From: Chris Niederman <Chris@niederman.com>
Sent time: 07/01/2021 03:57:41 PM
To: Andrew Leon
Cc: Mercer Island ePermit Tech
Subject: Re: 2015-227 Planning Review Comments
Attachments: 4 NIEDERMAN_GARAGE-DRIVEWAY GATE.pdf

From: Andrew Leon <andrew.leon@mercerisland.gov>
Date: Friday, June 18, 2021 at 6:09 PM
To: Chris Niederman <Chris@niederman.com>
Cc: Mercer Island ePermit Tech <epermit.tech@mercergov.org>
Subject: 2015-227 Planning Review Comments

I have completed my first round of review of your building permit to install an automatic electric gate at 6800 96th Ave SE, as process under permit number 2105-227. I have the following review comments:

SHEET NUMBER
SK-2

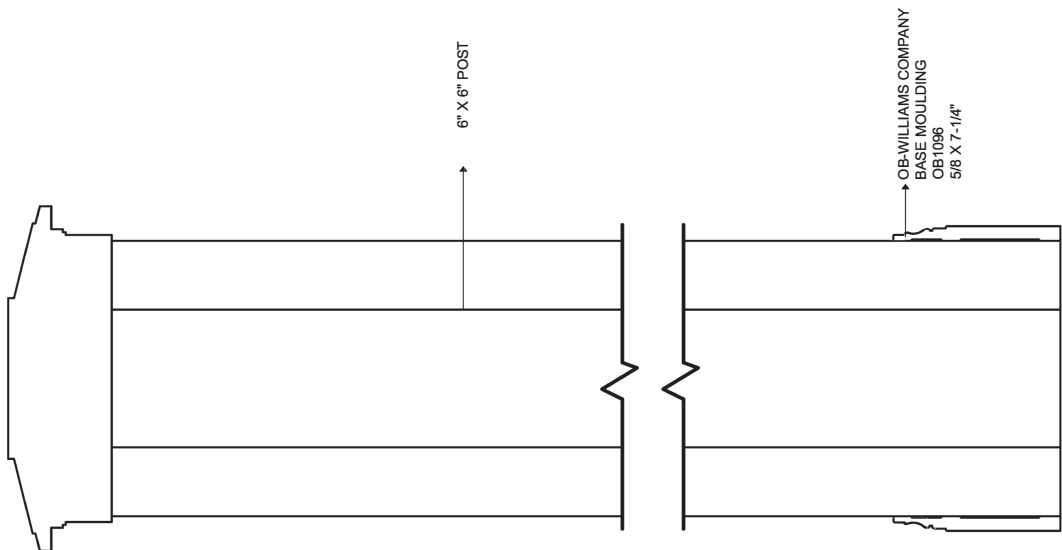
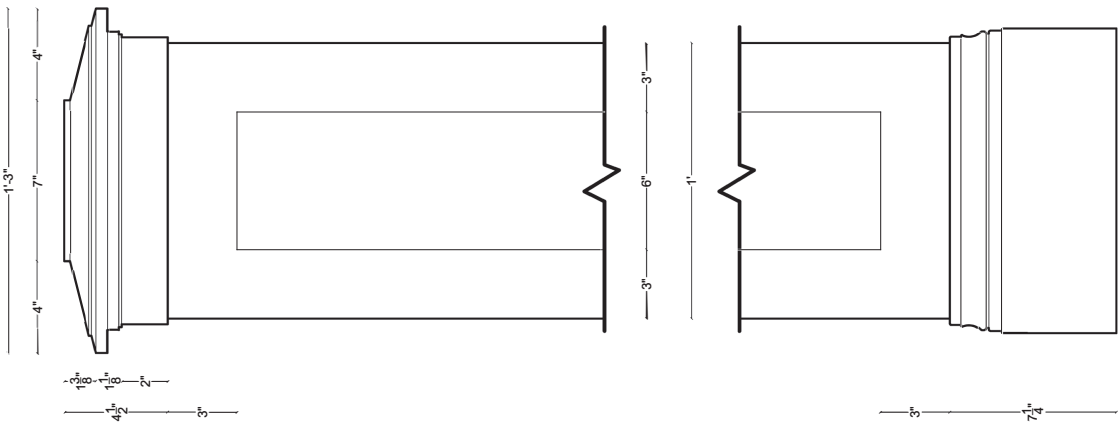
MIC 19.02.050(C)(1) states that the height of a fence is measured from the top of the fence, including posts, to the existing grade or finished grade, whichever is lower, directly below the section of the fence being measured. The lights are part of the posts, so they would also need to meet the 72-inch height limit for the fence.

- [MICC 19.02.050\(E\)\(1\)\(a\)\(i\)](#) states that fences and gates are allowed to a maximum height of 72 inches within required side yards. Further, [MICC 19.02.050\(C\)\(1\)](#) states that the height of a fence or gate is measured from the top of the fence or gate, including posts, to the existing or finished grade, whichever is lower, directly below the section of the fence or gate being measured.

The plans show that the posts of the proposed gate and fence are to be 78 inches in height, with elements extending above 78 inches. This exceeds the 72 inch height limit. Please revise the height of the posts so they meet the height limit listed in [MICC 19.02.050\(E\)\(1\)\(a\)\(i\)](#).
